# CITY OF ALBUQUERQUE

**RE: La Cuentista Unit 3 Subdivision – Lots 8-22 & 28-31**  
**Request for Pad Certification – Not Accepted**  
**Engineer's Certification Date: 05/17/23**  
**Engineer's Stamp Date: 12/10/21**  
**Hydrology File: D10D002D**

Based upon the information provided in your Certification received 05/18/2023 and site visit on 05/24/2023, the above referenced Certification **is not** acceptable for Building Pad Certification for **La Cuentista Unit 3 Subdivision – Lots 35-38, 40-43, 52, & 53**. The following comments need to be addressed for approval of the above referenced project:

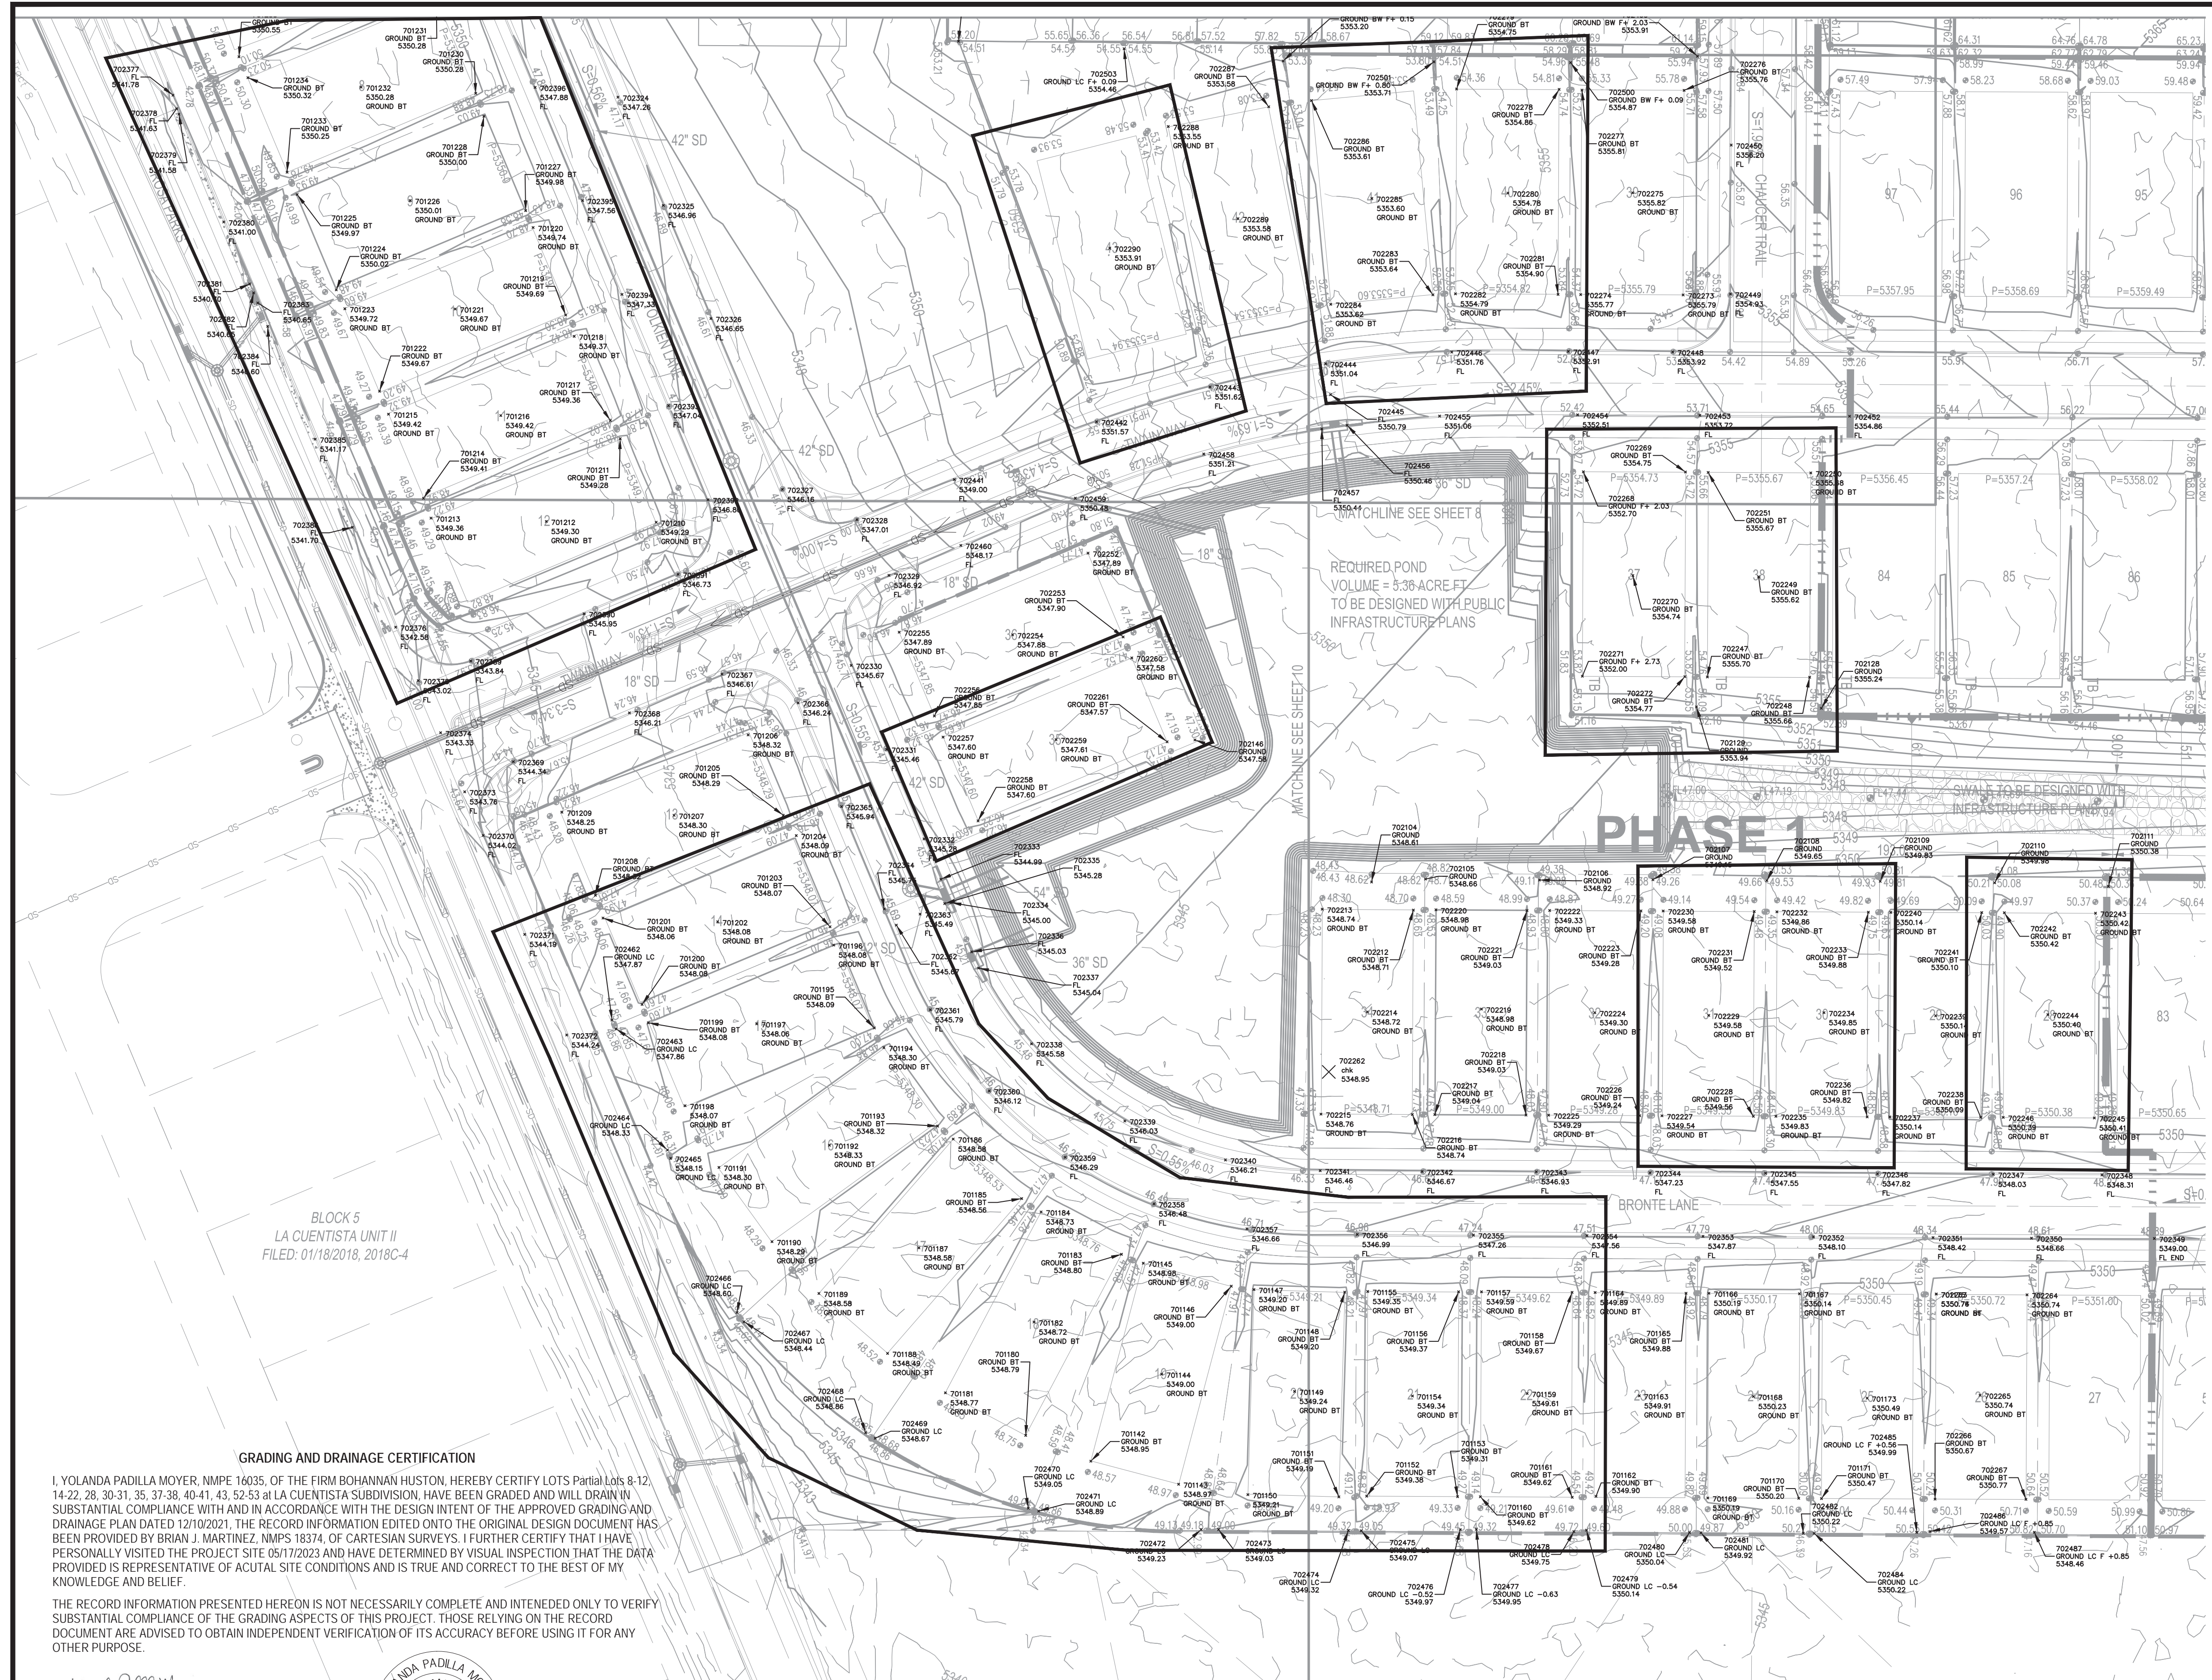
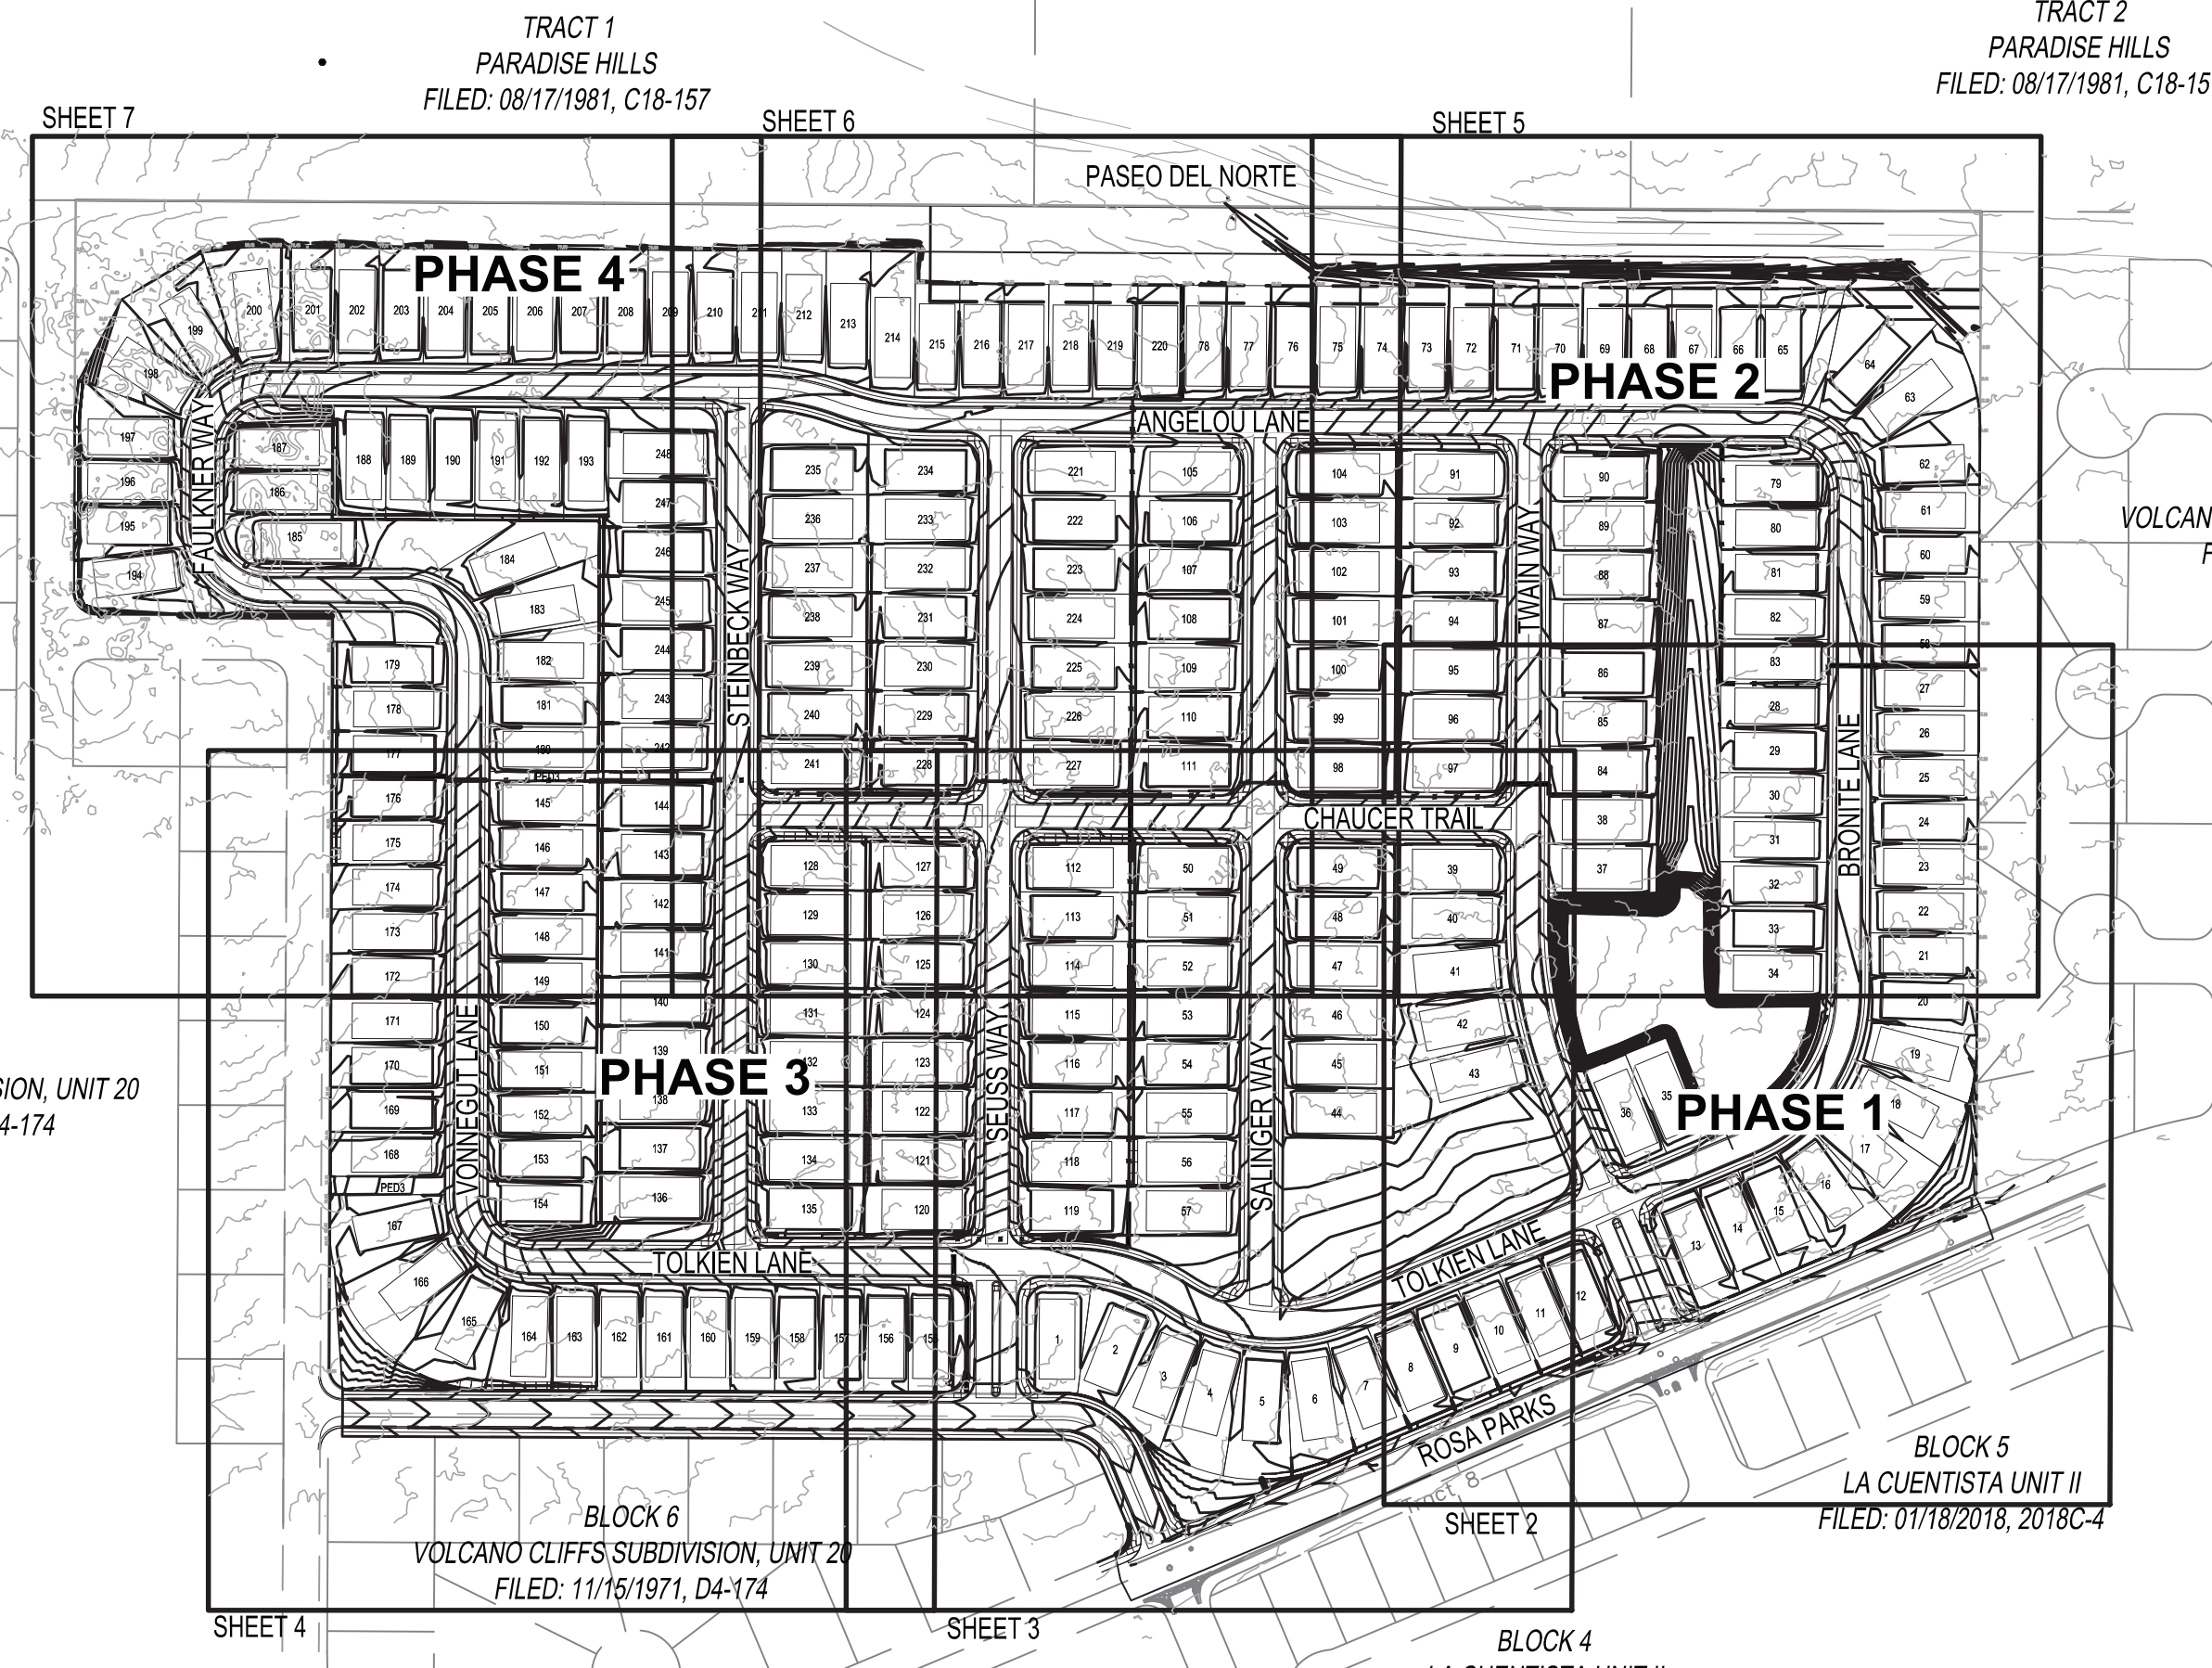
1. When I visited the site, there was a trench along the front of the lots and dirt piled up from the earthwork. Please ensure that the lots are ready for pad certification prior to the next request.
